Invalid Application

Proposal: Listed Building Consent to replace 8 no. windows (3no. to the front and 5no. to the rear) with wooden sash windows, and repairs to window frames, to replace rear ground floor and kitchen casement windows with traditional sliding sash windows, and to replace the front door with a new hardwood painted door

Location: 12 Church Street Croston Leyland PR26 9HA

Reference: 22/00322/LBC

OFFICE COPY issued by
LANCASHIRE
DISTRICT LAND REGISTRY
Title No: LA969259
COPY (liable to distortion)
of plan to CONVEYANCE
dated 17.6.1964

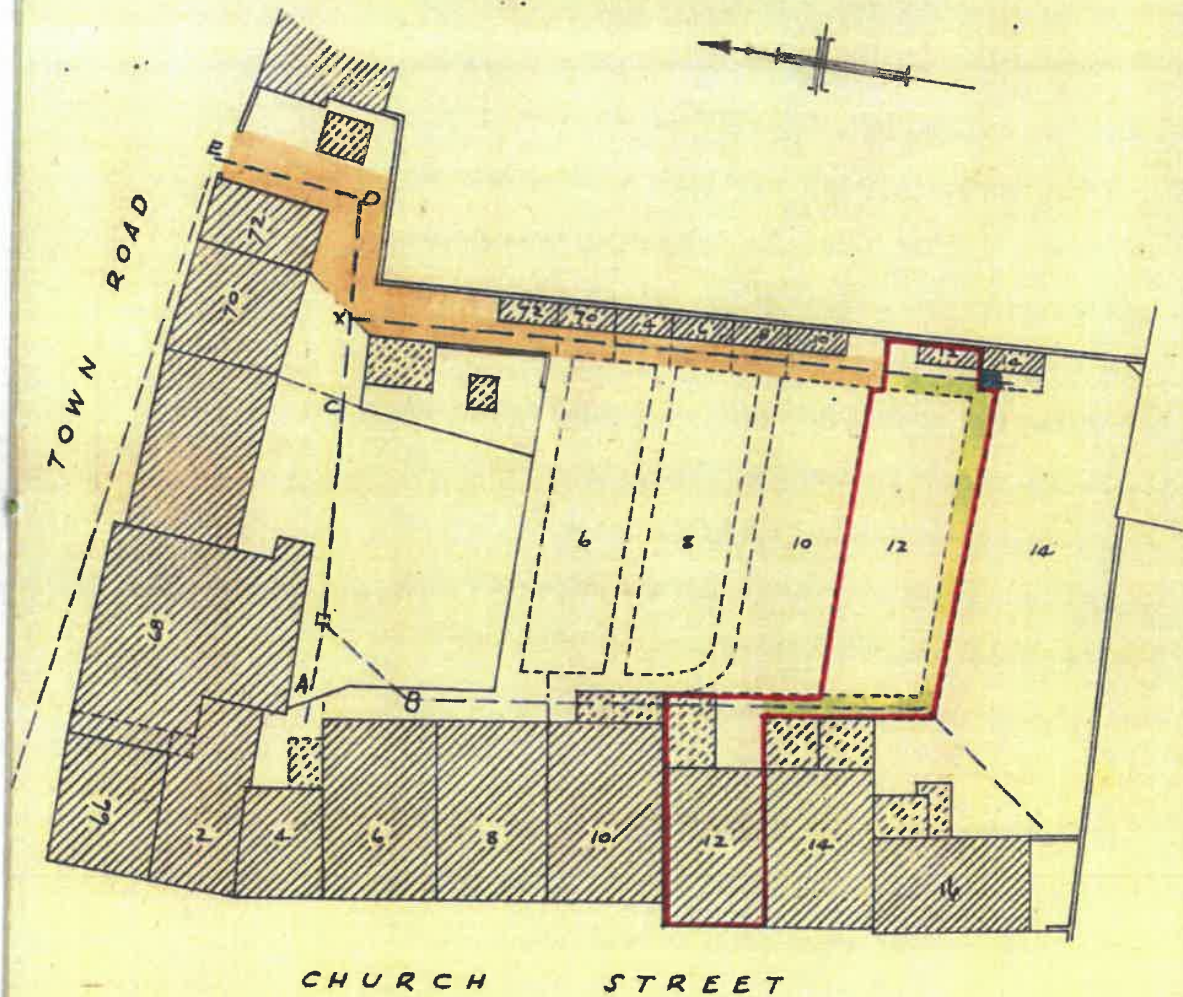
- The location plan submitted needs to be replaced as it needs to be based on an up to date map at a scale of 1:1250 or 1:2500. The buildings should be numbered/ named to ensure that the application site is clearly identified. The application site should be edged clearly with a red line – on the submitted plan the red line appears to include land that is not related to the proposed works so this should be reviewed, and a blue line should be drawn around any other land owned by the applicant, close to or adjoining the application site.
- A site plan and block plan are required. The site plan should be drawn at a scale of 1:500 or 1:200 and the block plan at 1:200 or 1:100 and should accurately show:
